# Tree Conservation Report Addendum

## Submitted as part of Site Plan Control Application

**Address:** 29 Russell  
**Date of Report:** Dec 22, 2023  
**Date of Site Visit:** Dec 15, 2023  
**Prepared by:** Astrid Nielsen, RPF, ISA Certified Arborist ®  
**Client:** Smart Living Properties, Corey Kou, [corey@smartlivingproperties.ca](mailto:corey@smartlivingproperties.ca)

1 TREE CONSERVATION REPORT & LANDSCAPE PLAN
SCALE 1:100

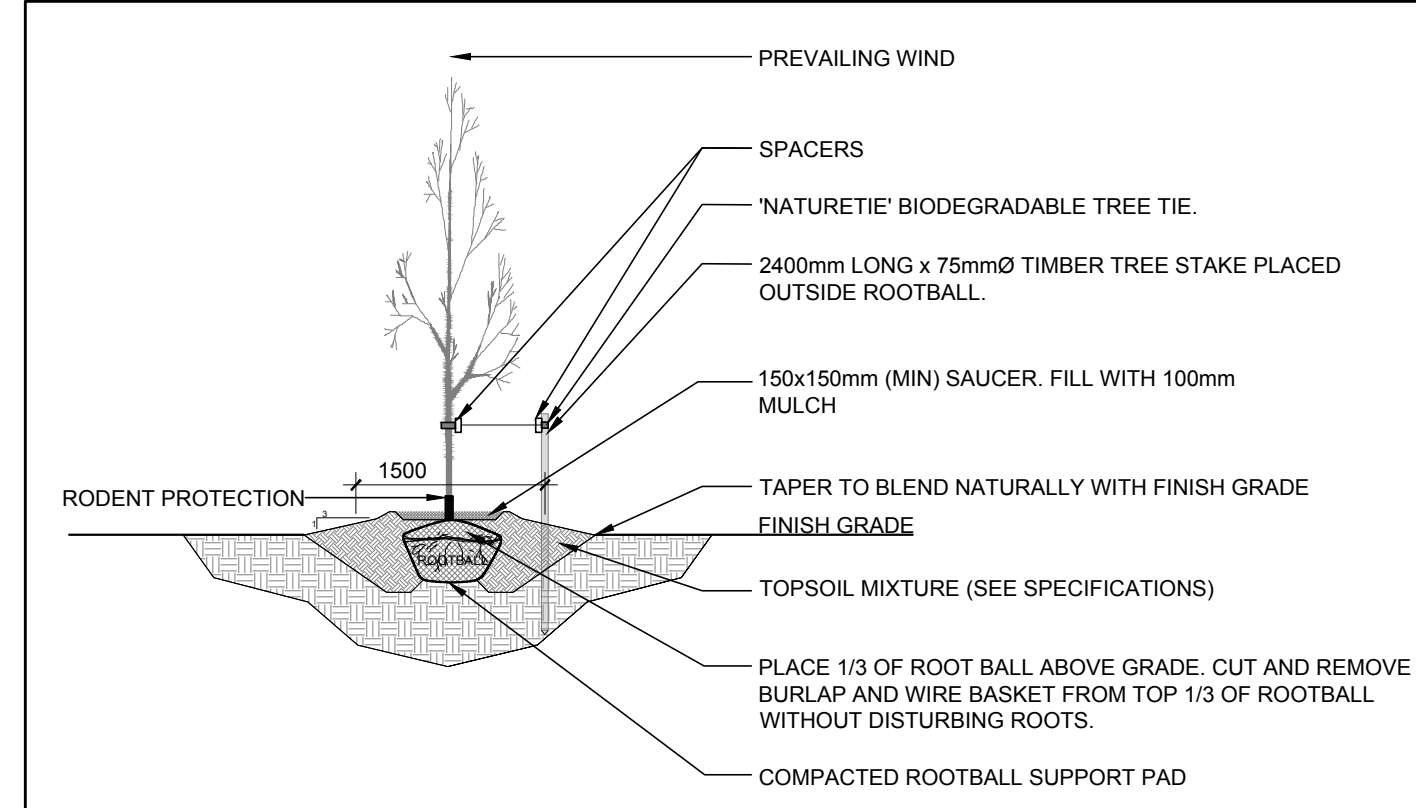
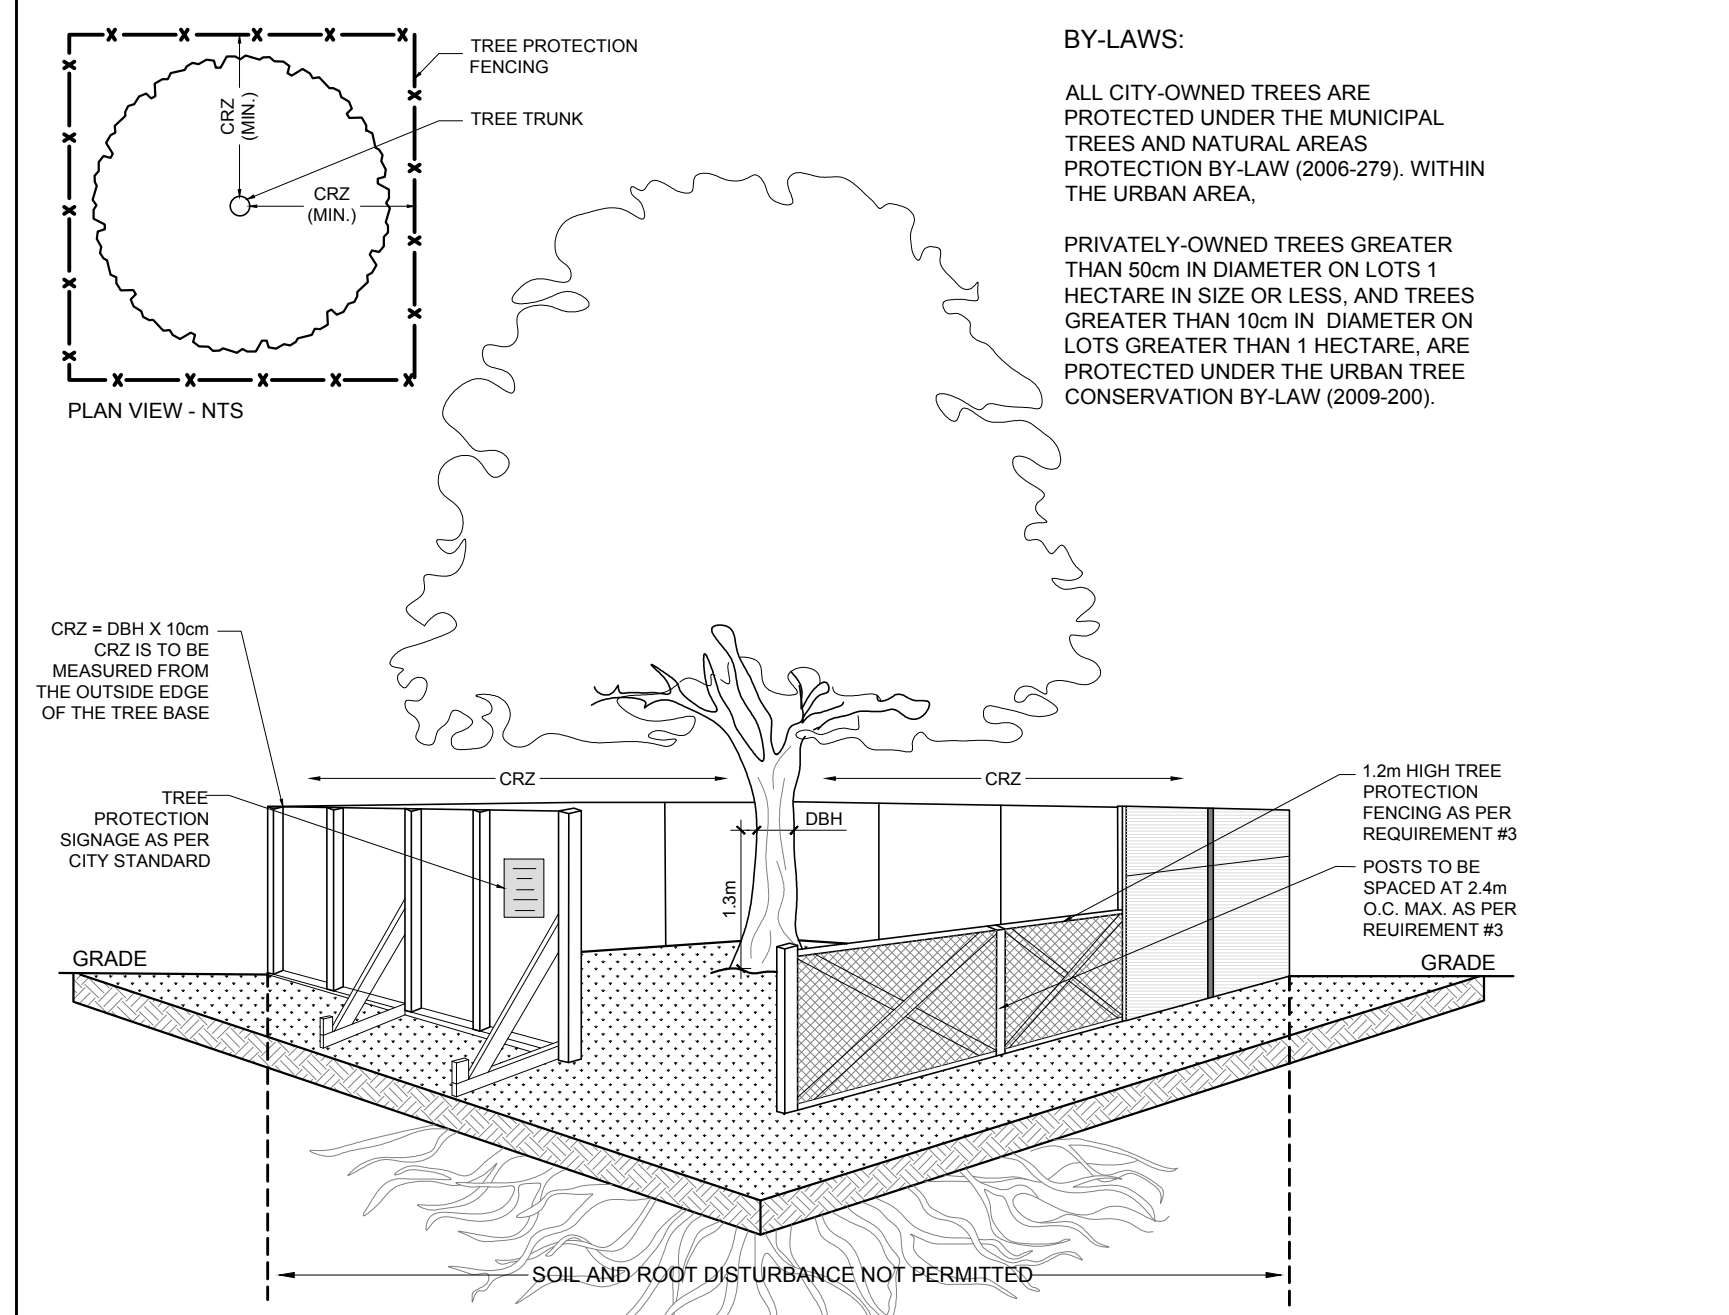
*4. [City 3rd Review, Comment 18] The 7 Manitoba maples owned by 312 Laurier are expected to have >30% excavation within their CRZs. Consideration should be given to reducing the extent of excavation needed in this area, reducing tree impacts. If this cannot be done a report from a Registered Professional Forester (RPF) will be required indicating that the trees will be safely retained and are expected to survive construction.*

*City (December 2023) – The comment has not been adequately addressed. It was indicated in the response to the 2nd submission that >30% of the CRZ of adjacently owned trees would be impacted by the project. This is not an acceptable level of impact under best management practices. As noted in the previous comment, reduce the impact or have a registered professional forester sign off on the current plans as being an acceptable retention plan. No revised plan and/or evidence of reduced impact was provided nor has a registered professional forester signed off on the current plans as being an acceptable retention plan.*

Based on these calculations, rooting loss ranges from 0-15% with the exception of tree 2 which may have up to 29% root loss. 0-15% root loss may result in some tree health decline but will be unlikely be the sole reason to cause decline in these trees. Investments into mitigations to reduce root loss for tree 2 is not recommended as the tree is already in poor condition. Both **Trees 1 and 2** are in poor condition, and removal, or reduction pruning should be considered by the property owner to reduce the risk of failures onto the parking lot.

Other mitigation measures include reducing impact to tree roots as much as possible during the excavation for the new foundation. This could include cleanly severing by hand any roots larger than 1" and keeping any exposed roots moistened as much as possible; this could be accomplished by covering them with soil or covering the wounds with a moist organic material such as burlap. The tree protection area will likely need to be accessed during the construction, but the ground is already heavily compacted, so additional foot traffic is unlikely to cause further damage. The area immediately around the trees, however, should be avoided and fenced off to avoid construction material and machinery from damaging the trees directly.
